RPS
6-7 Lovers Walk
Brighton
BN1 6AH

Date: 29th April 2014

GRUNDON FORD SITE: REPONSES TO FURTHER COMMENTS RAISED BY ACOUSTIC ASSOCIATES SUSSEX LTD

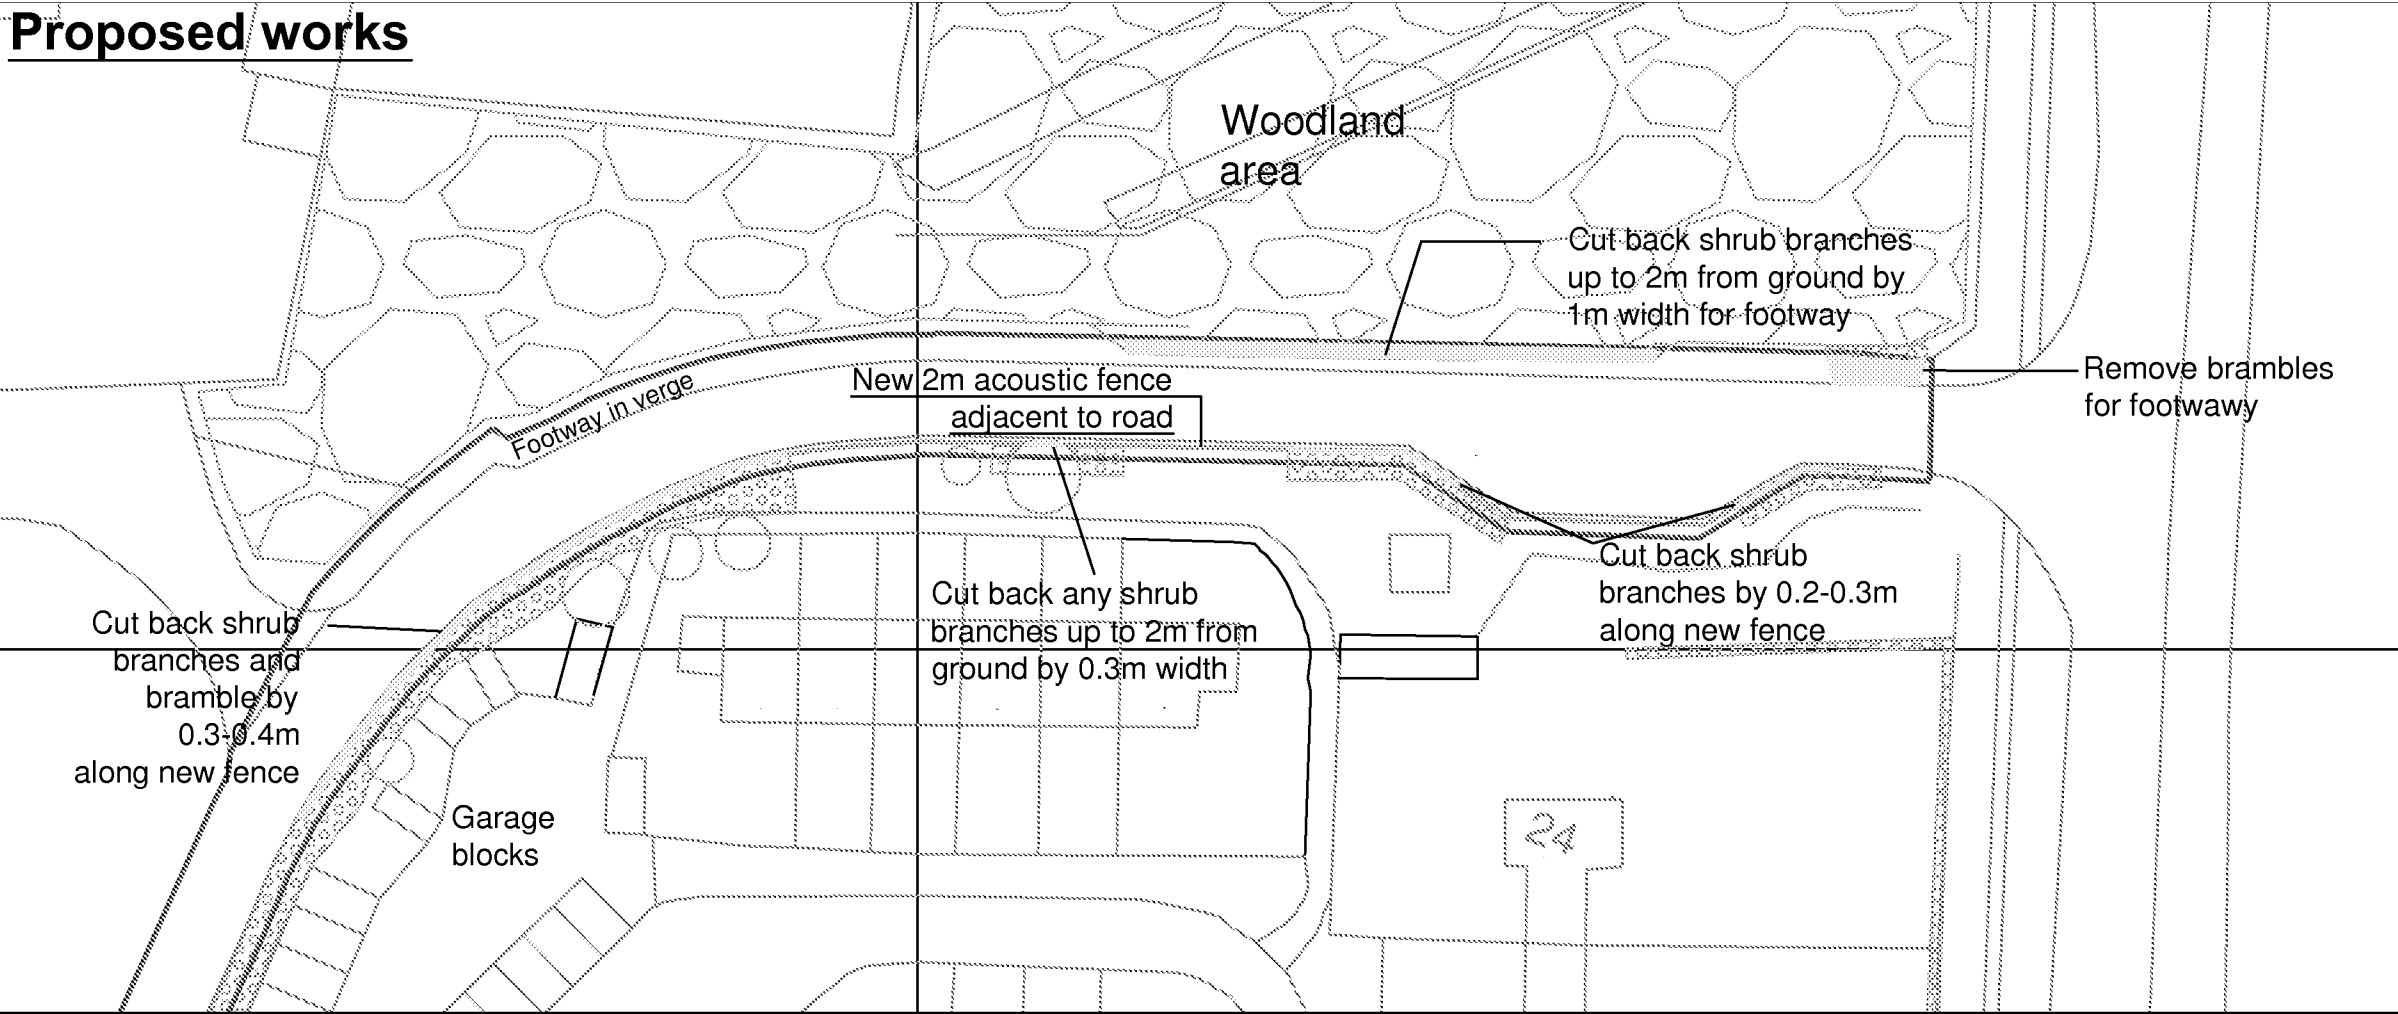
- 7 As it has also now been proposed to install a 2 m noise barrier on the eastern access road to mitigate the noise levels at properties close to this road, this has now also been included within both the noise models for construction and operation of the site. The location and extent of the noise barrier is provided in Figure 1.
